Silverleaf Solar Farm (SSD-9358)
Request for additional information

I refer to the assessment of the Silverleaf Solar Farm (SSD-9358). The Department is requesting that you provide additional information addressing the items below:

Client	NSW GOVERNMENT
Project	NARRABRI SOLAR FARM SILVERLEAF
Title	KAMILAROI HIGHWAY / LOGANS LANE INTERSECTION UPDGRADE - BAR ONLY OPTION
Original Size	A1
Drawing No:	22-12518304-SK003
Rev:	C

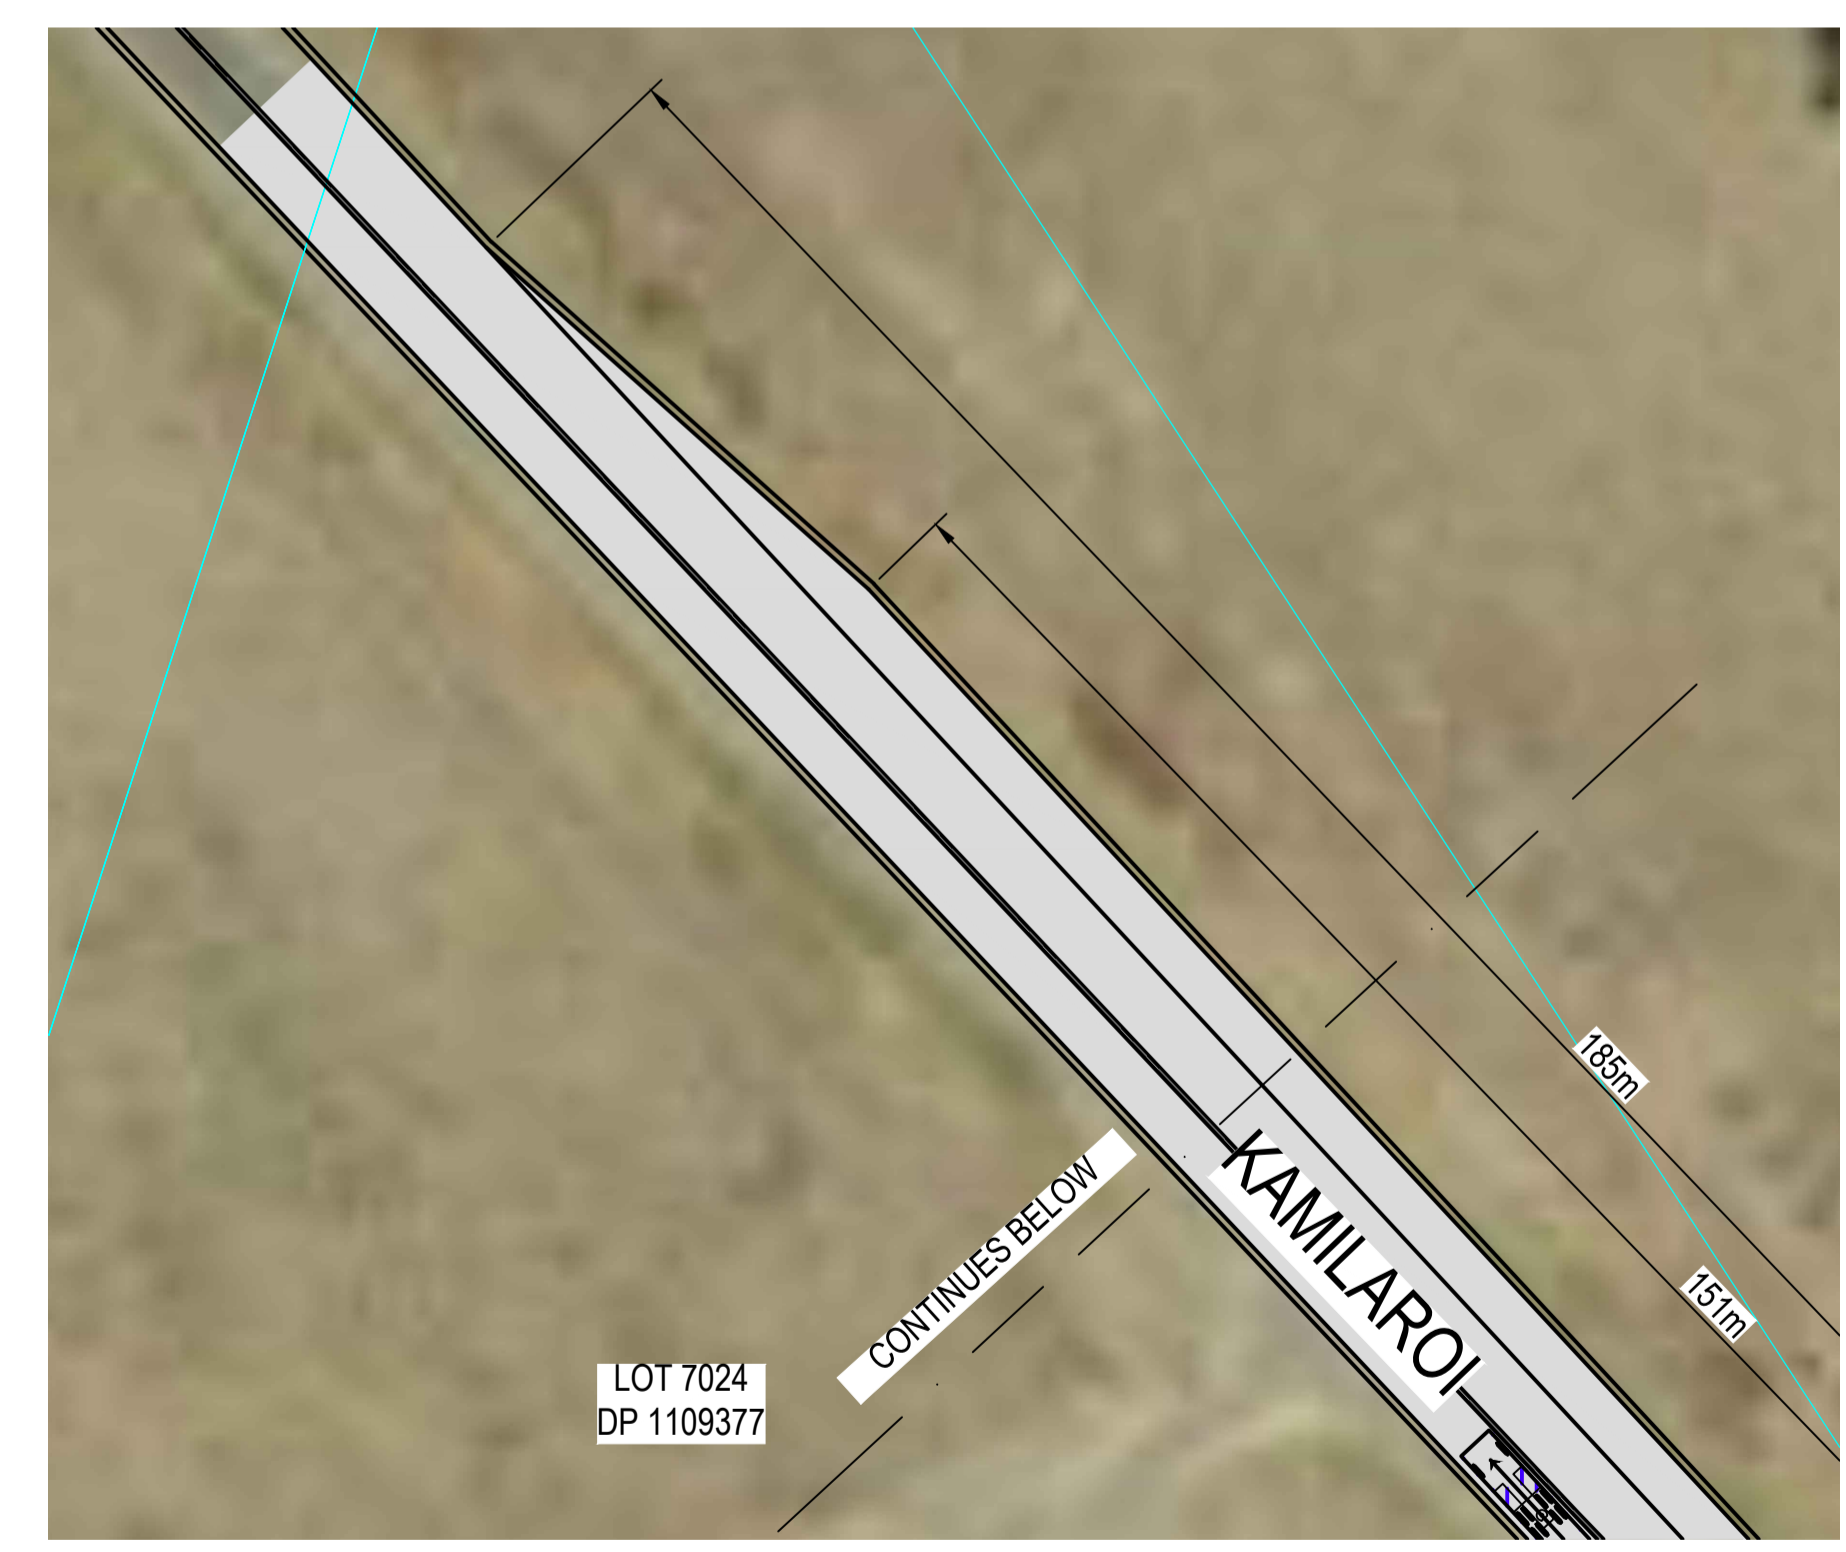
- Revised drawings for the treatment of the intersection of Kamilaroi Highway and Logans Lane, incorporating a Basic Left Turn (BAL) treatment in accordance with Transport for NSW requirements.
- Confirmation that the revised intersection treatment will not have additional impacts on native vegetation or heritage.
